ENG-PUDSP21002-R1-GEC.pdf Markup Summary

OVERLOT GRADING / E

VICINITY MAP
NO SCALE

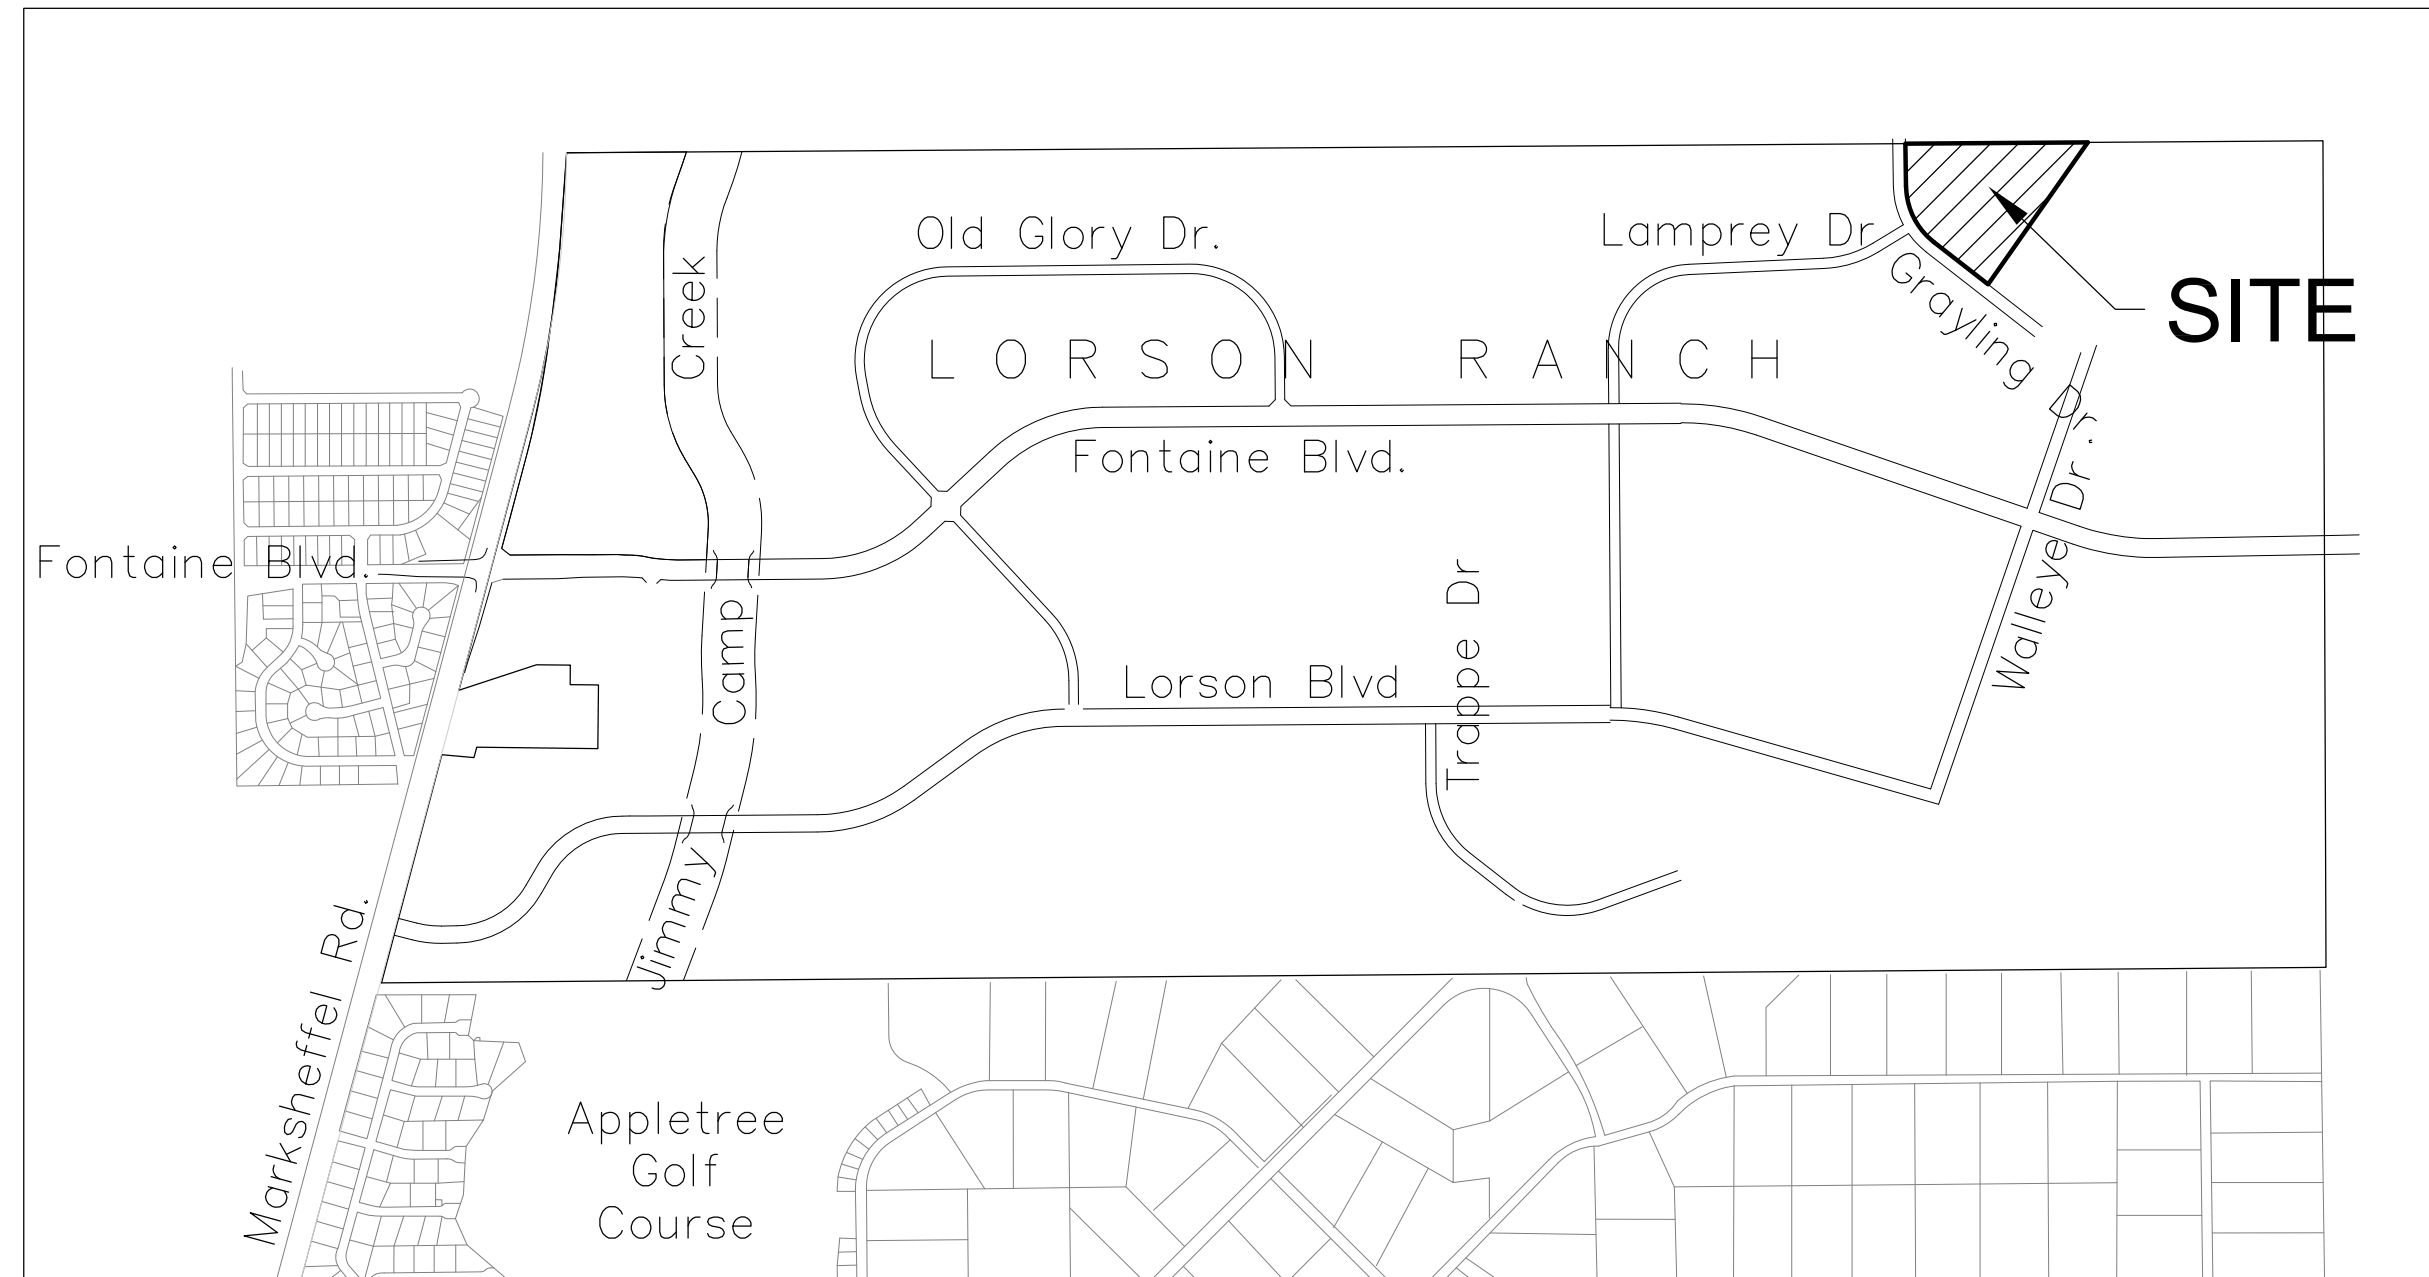
Please show Pond C4 on Vicinity Map

**TYPICAL SECTION 50' R.O.W.
RESIDENTIAL URBAN LOCAL**
NOT TO SCALE

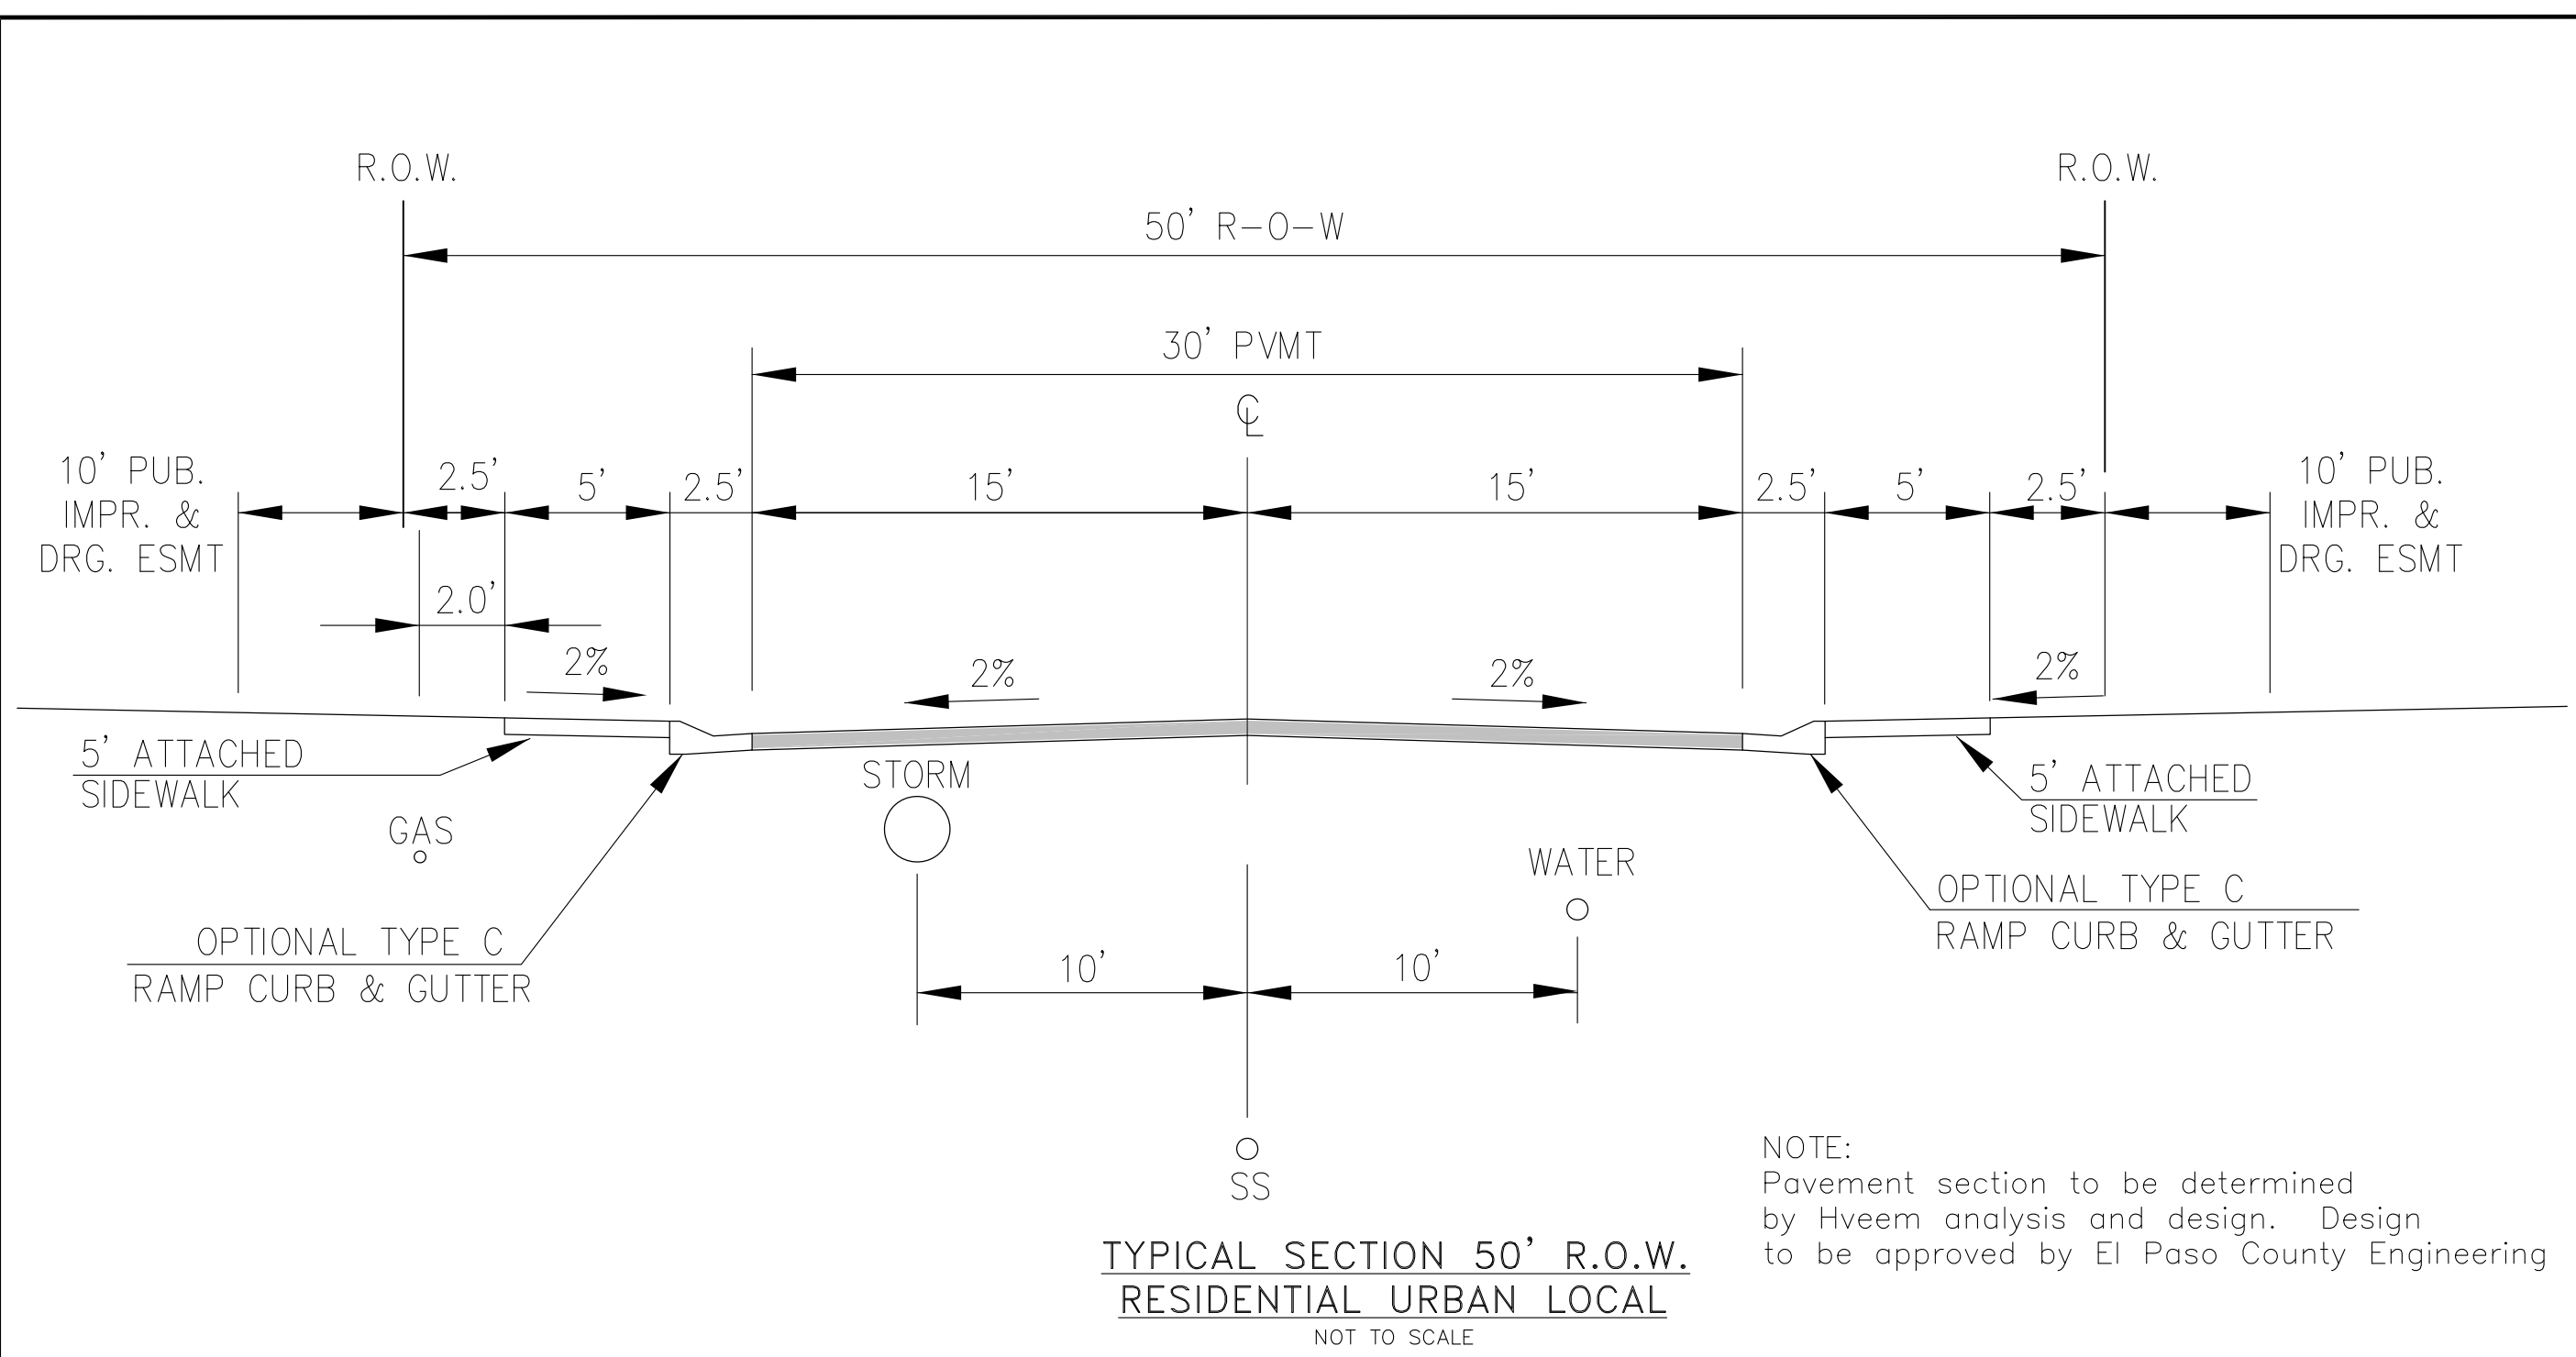
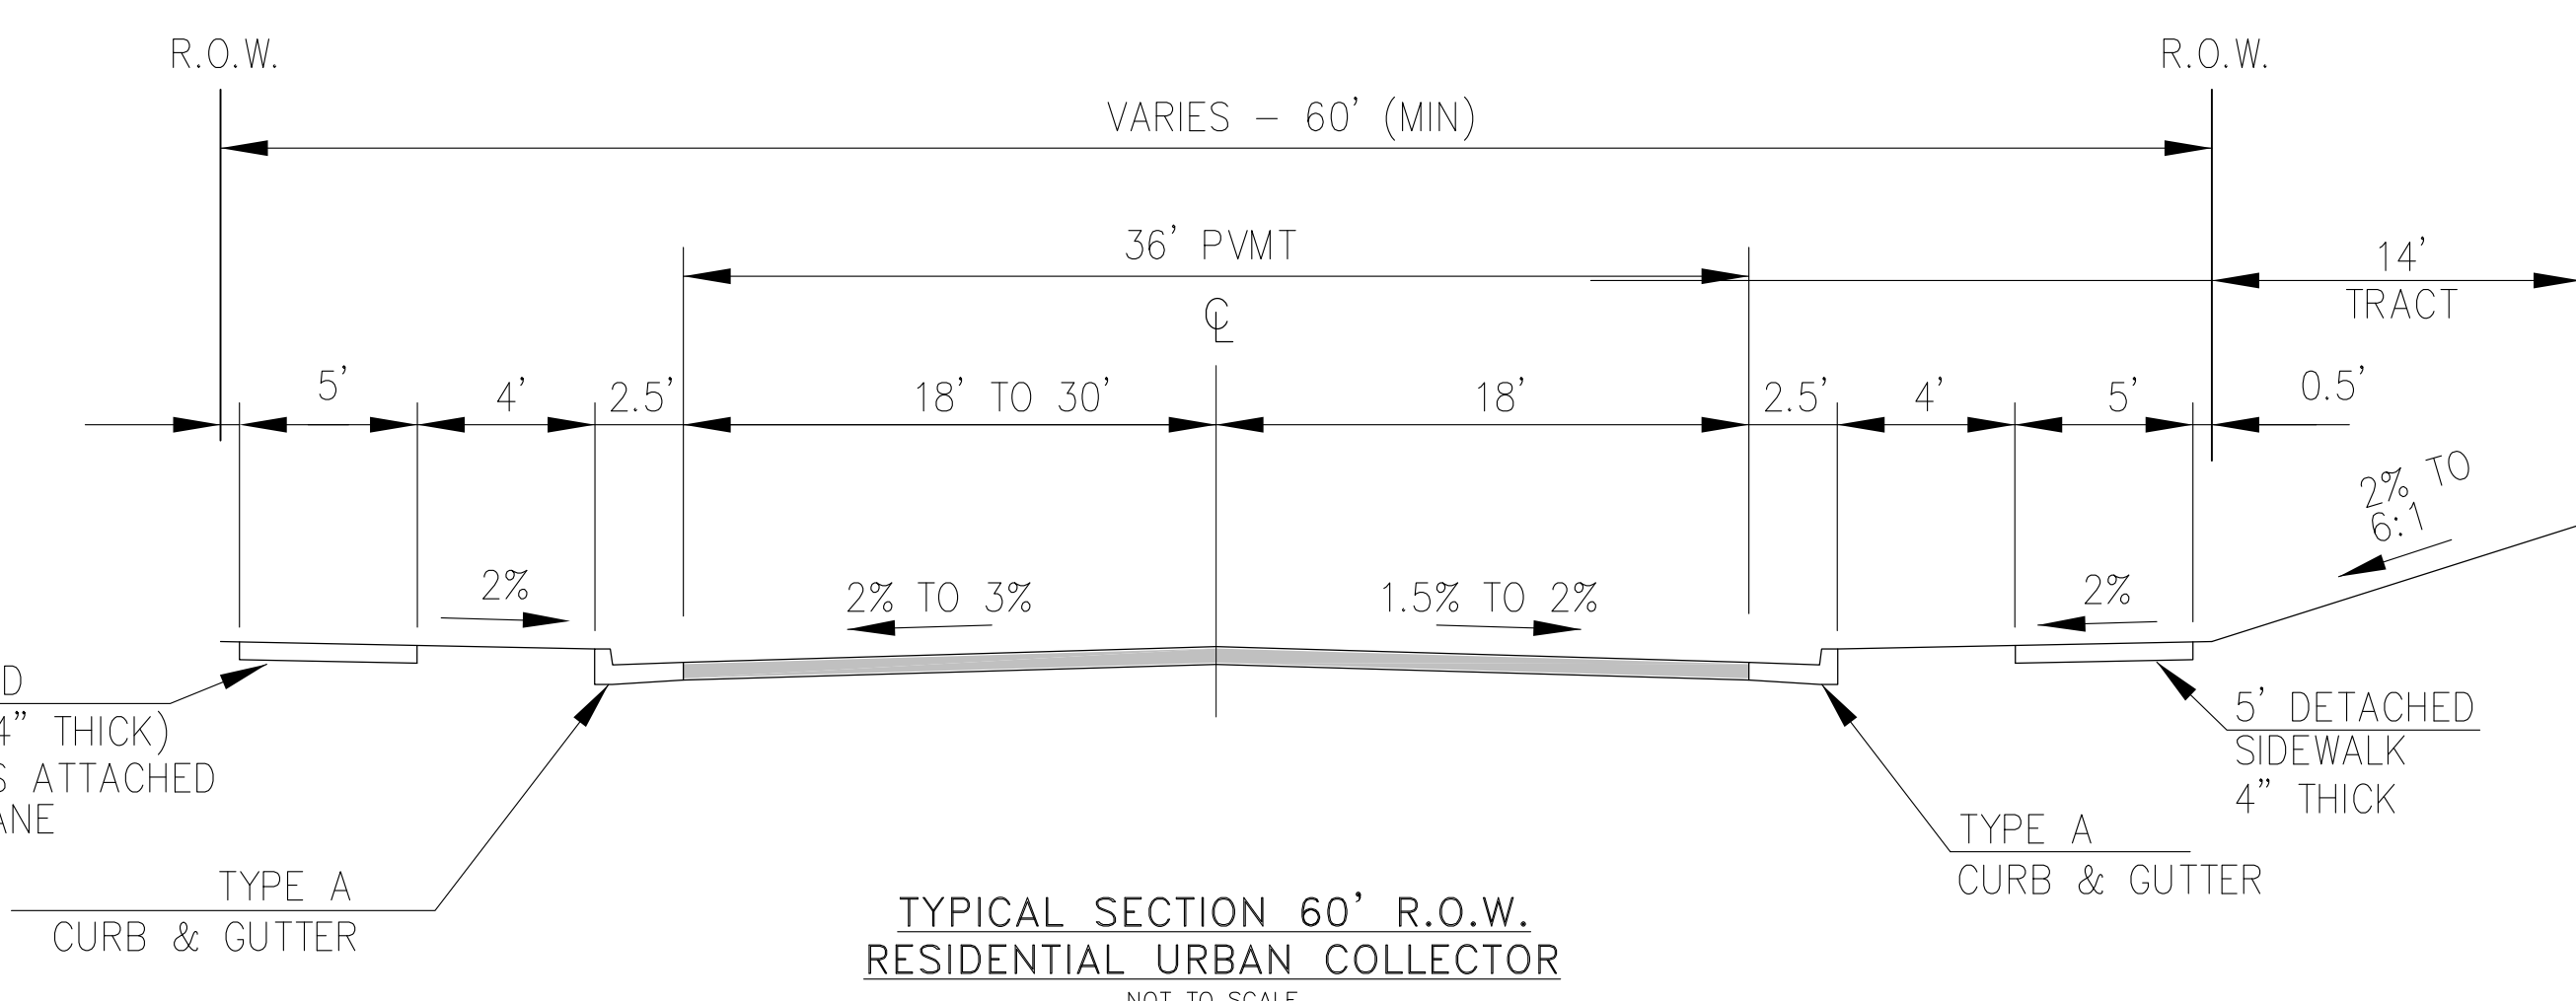
for early grading, do not show asphalt or concrete sidewalks on road detail
